Thank you for providing the amended block plan. However, the dimension to the rear boundary is also required. Please review and amend accordingly.

Request for further information R/150/21/HH

Block Plan
(Scale 1:500)

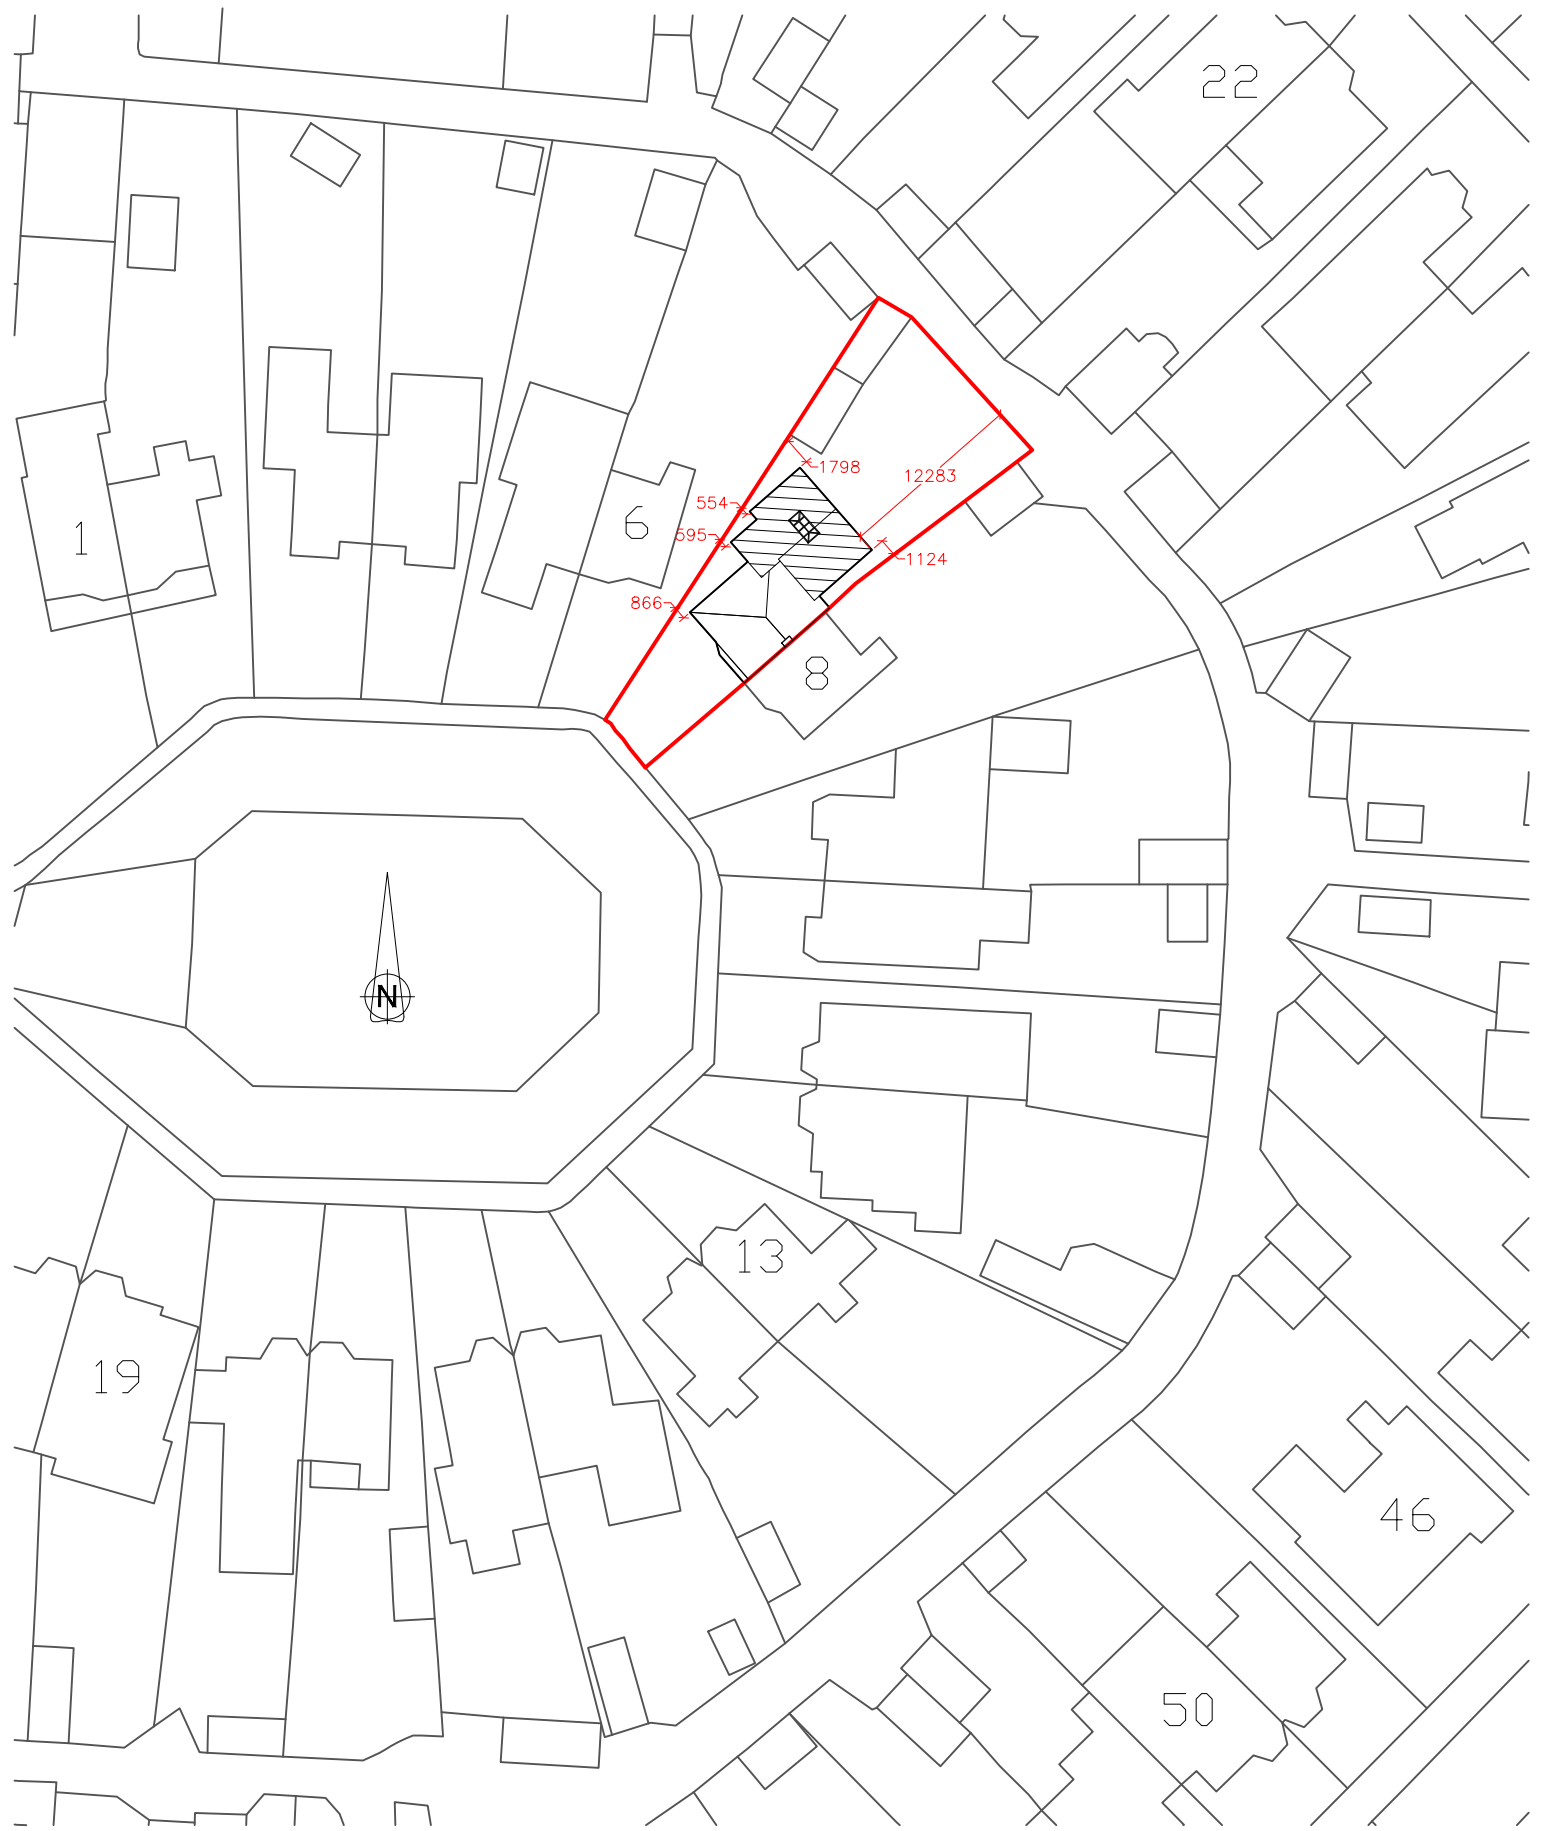
However, this application is still invalid as the block plan requires dimensions from the proposed extension to all relevant site boundaries. Please amend.

Please see attached proposed drawing with boundary dimensions.
